STERLING RANCH - SANITARY INFRASTRUCTURE 4" FORCE MAIN (CSU)

STERLING RANCH - SANITARY INFRASTRUCTURE 4" FORCE MAIN SANITARY SEWER

Markup Summary 7-23-2019

File: C:\09010A\San Sewer\Const Dwg\4th FORCE MAIN\FM02.dwg Plotstamp: 7/3/2019 4:00 PM

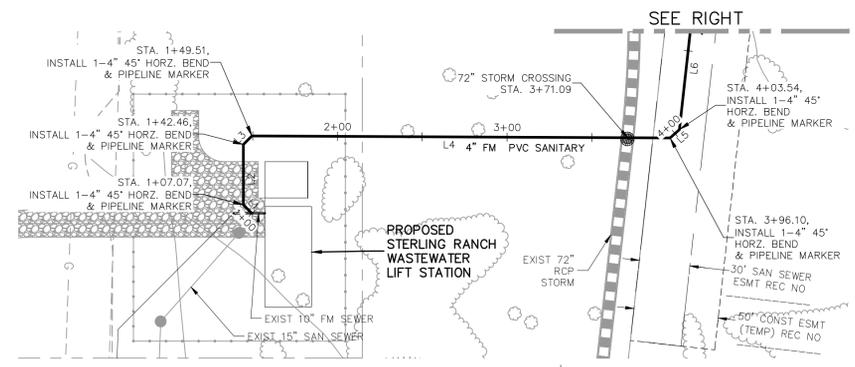
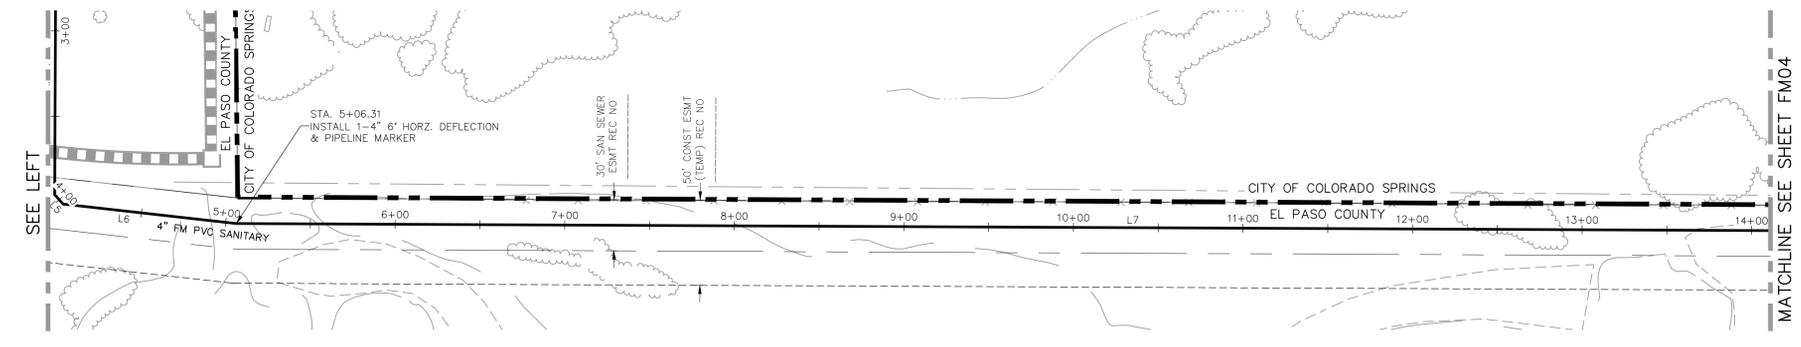
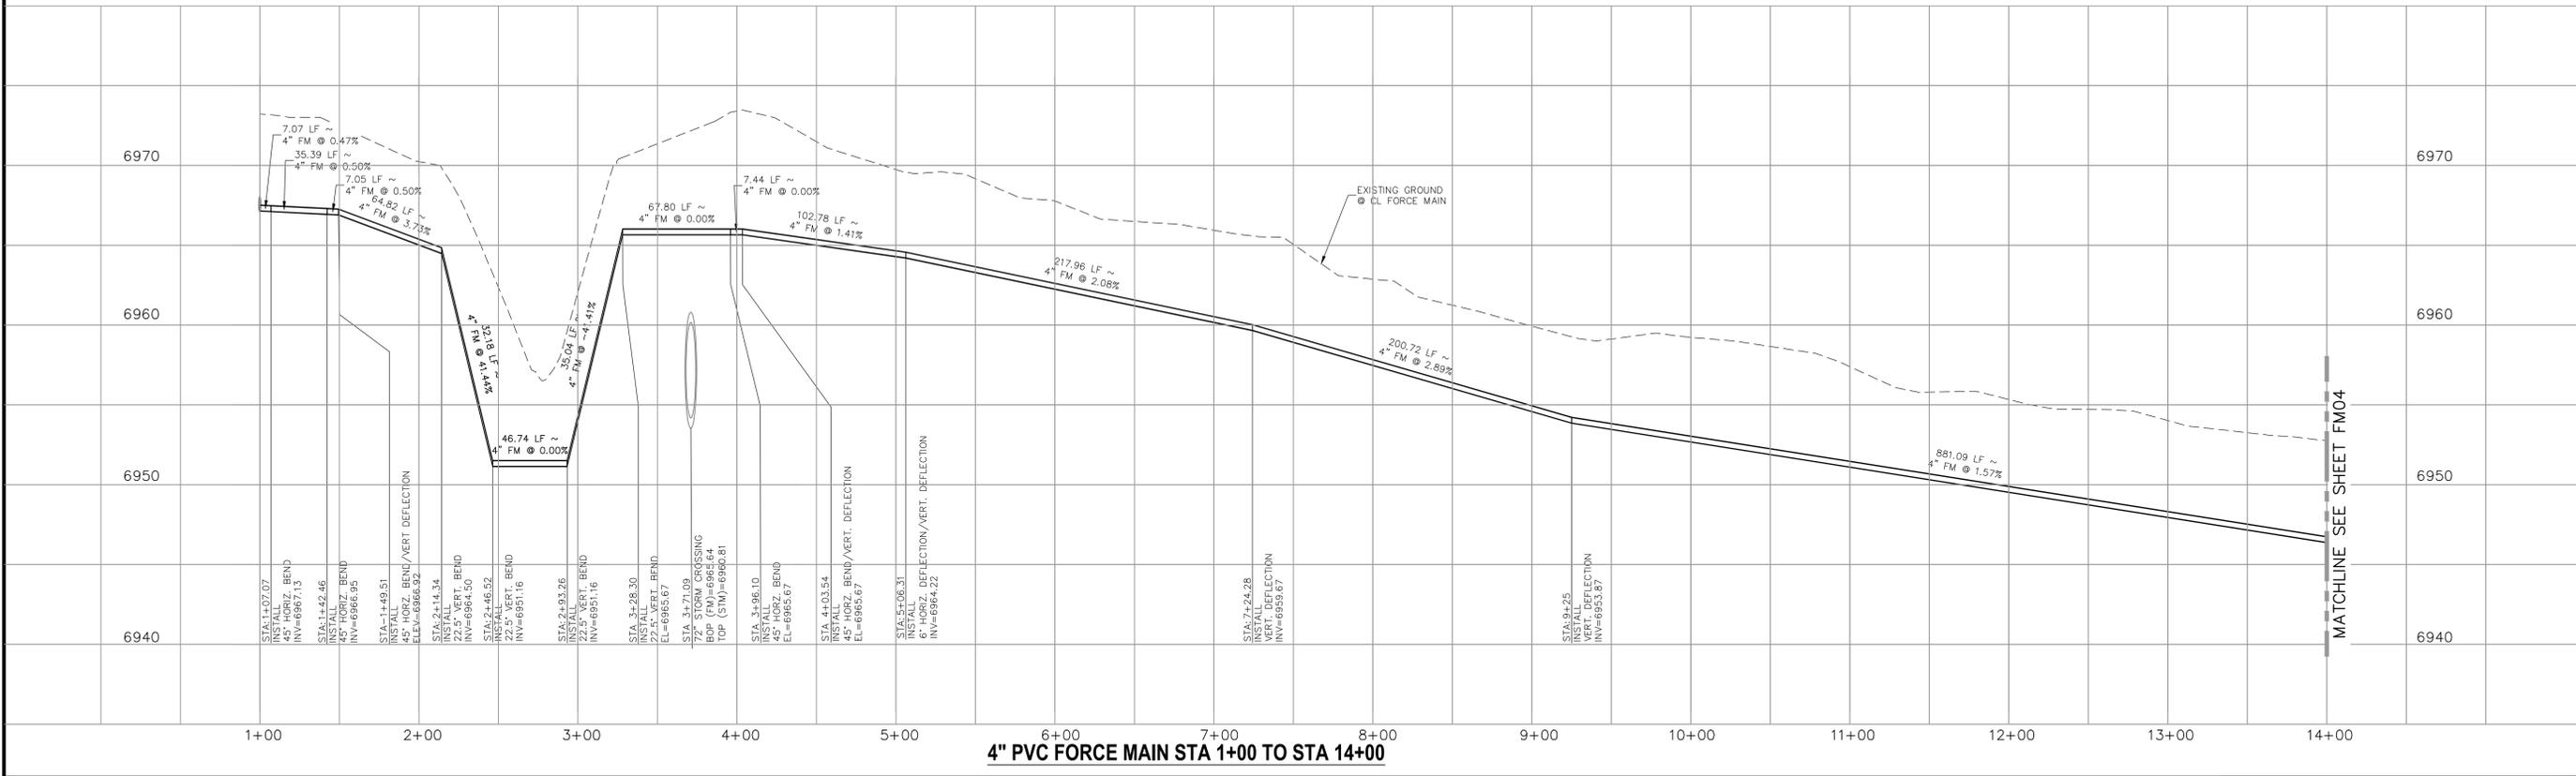
As evident in EDARP lift Stations do have a dite dev plan prior to construction

please see the checklist for SDP (plot plan) I removed many items from standard plan

Provide an inset with the platted lots ; overall parcels and the lift station and the proposed line.

where are the property lines for Sterling Ranch Parcels? Is the lift station in its own parcel? please show....

Notes detailing easements that line runs through with reception numbers if not owned by applicant/owners

property/parcel lines should be clear and the ownership of the lines and underlying zoning should be noted.

landscape screening? revelation seed mix for lift station
